An
Bord
Pleanála

Inspector's Report

ABP-317679-23

Development	Ringsend to City Centre Core Bus Corridor Scheme.
Location	Ringsend to City Centre, Co. Dublin.
Planning Authority	Dublin City Council North
Applicant(s)	National Transport Authority
Type of Application	Application under Section 51 (2) of the Roads Act 1993 as amended
Observer(s)	Refer to Appendix 1
Prescribed Bodies	Transport Infrastructure Ireland Dublin City Council Department of Housing, Local Government & Heritage
Date of Site Inspections	18 th January & 12 th March 2024
Inspector	Liam Bowe

RINGSEND TO CITY CENTRE CORE BUS CORRIDOR SCHEME STRUCTURES RINGSEND 05 - DODDER (OPENING) BRIDGE - PLAN & LONGSECTION - SHEET 1 OF 6 Sheet Number Status

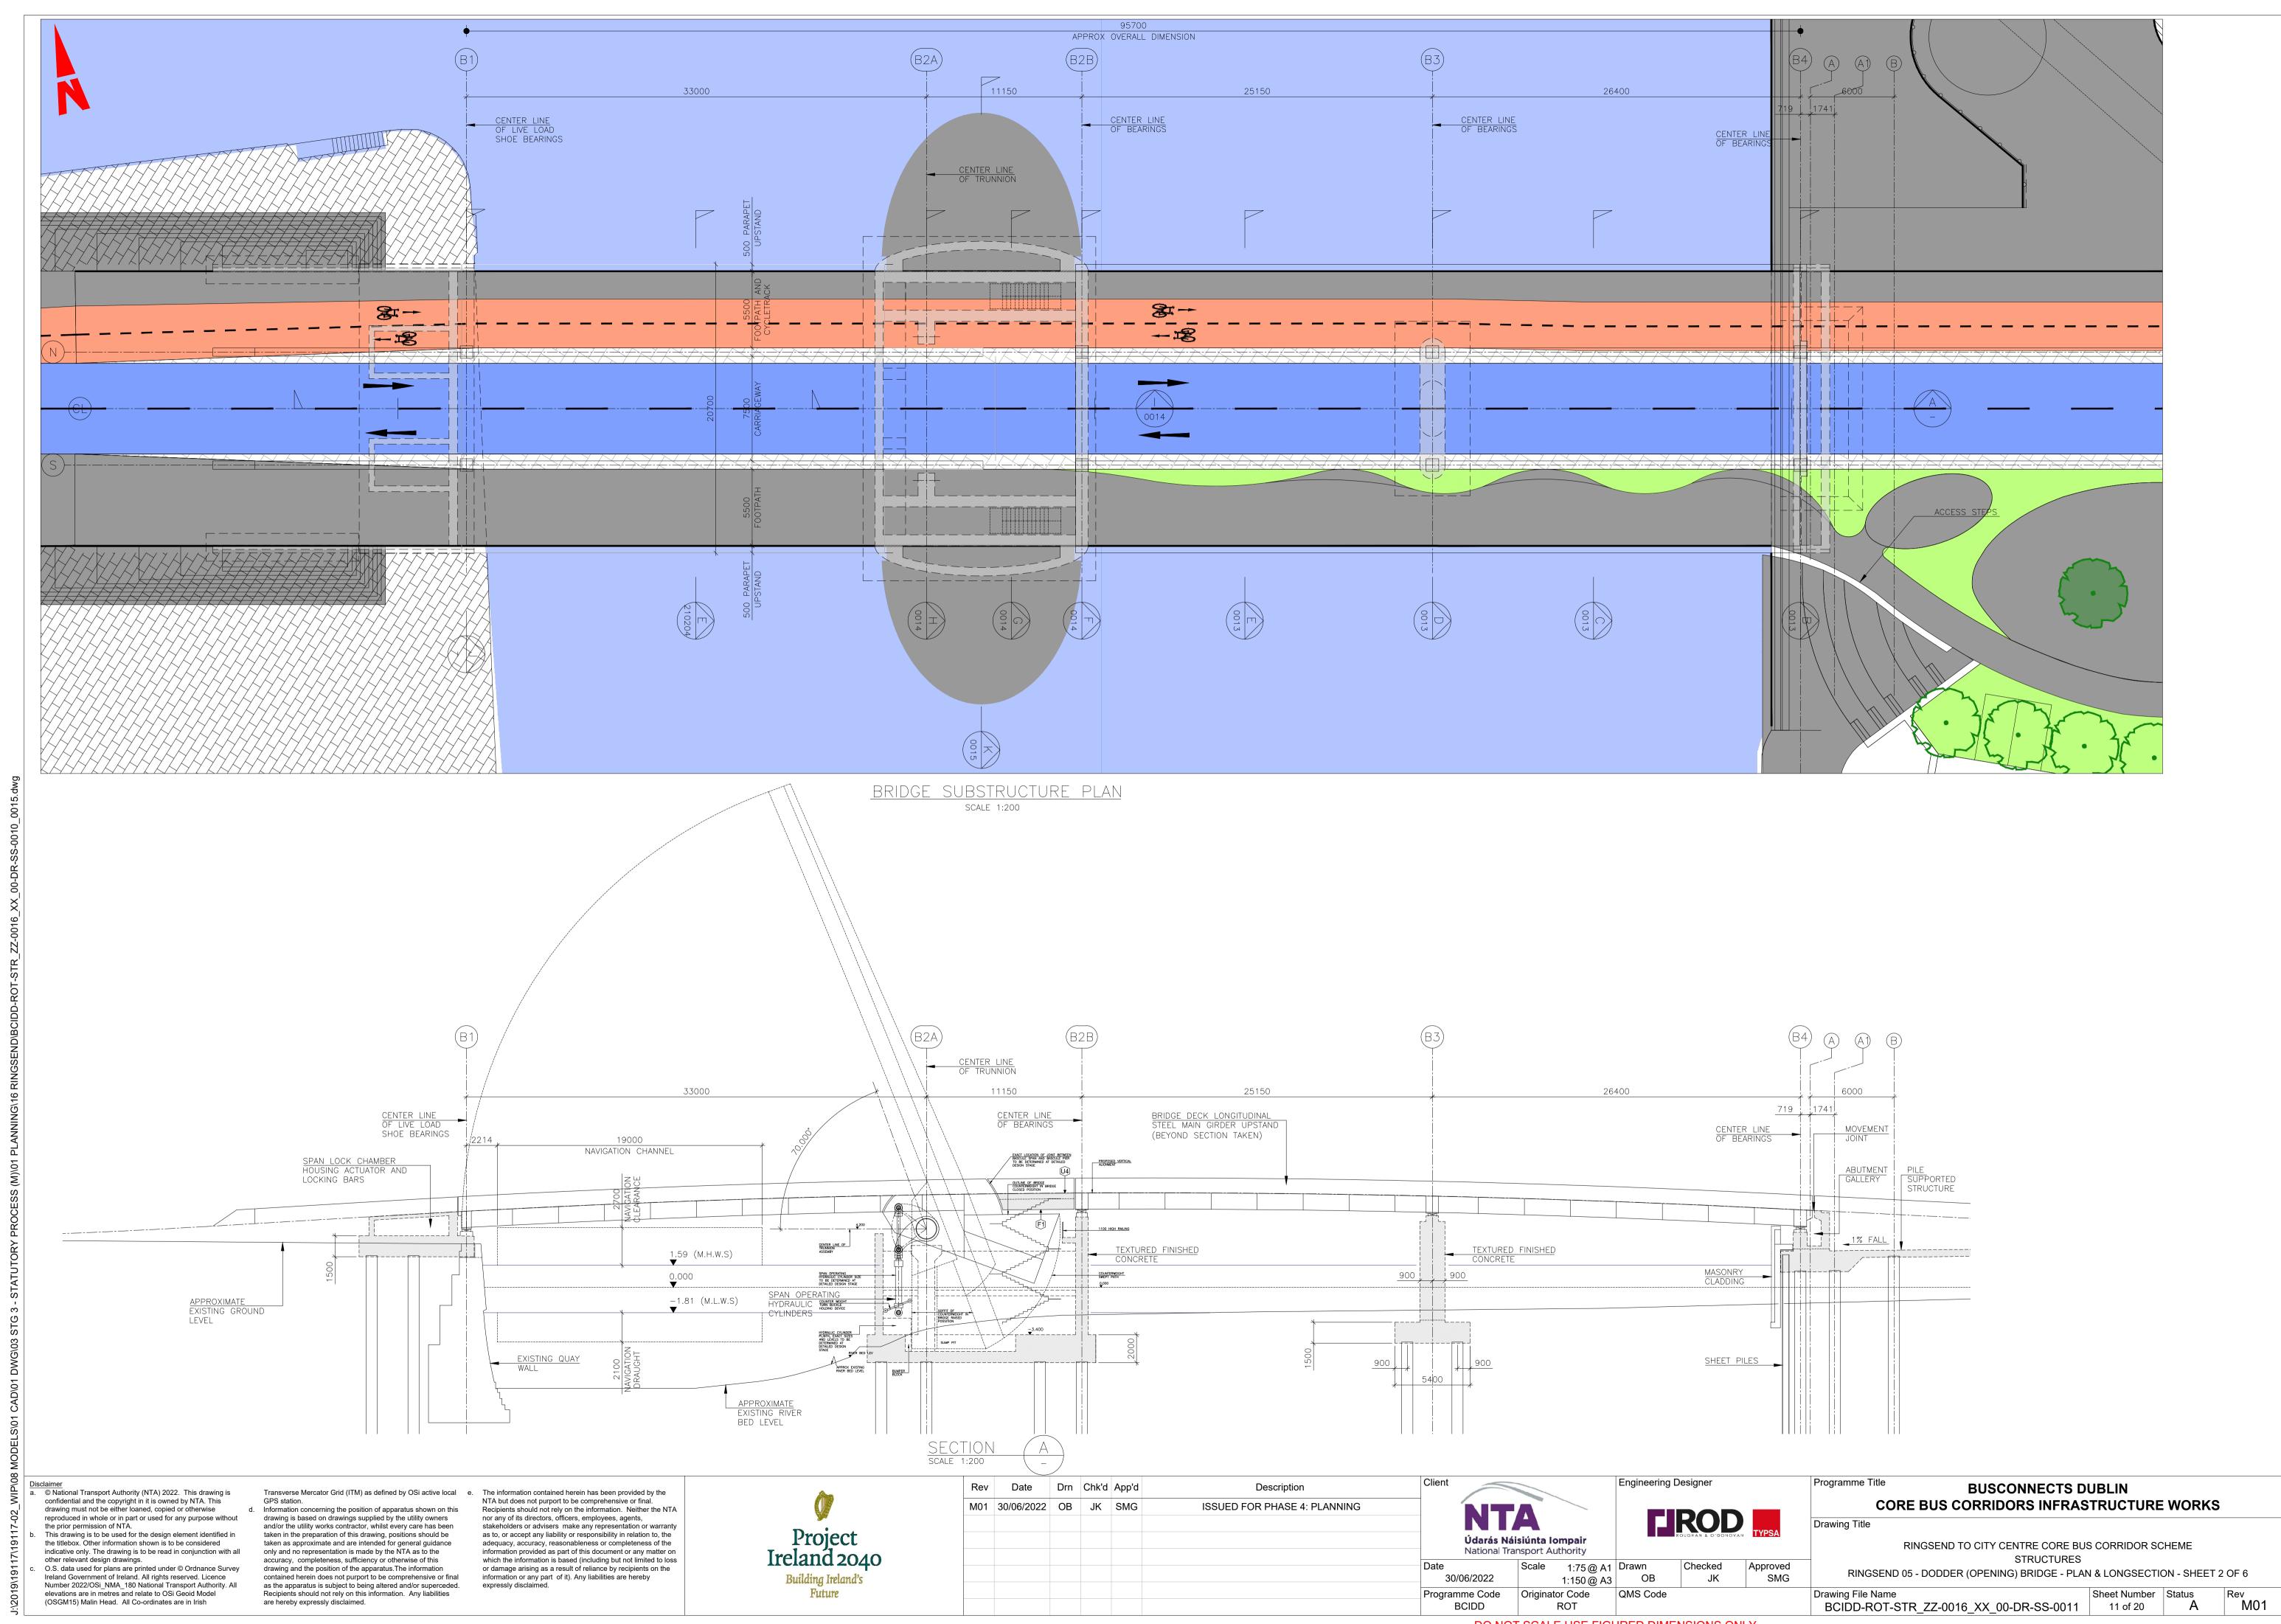
- Highlights that the proposed route will pass through three designated Conservation Areas, namely Liffey Quays, Royal Canal and Grand Canal & Dodder.
- Request that the DPTOB (new bridge) design be enduring and of exceptional quality to ensure that it enhances the Grand Canal & Dodder Conservation Area setting rather than detracting from it.
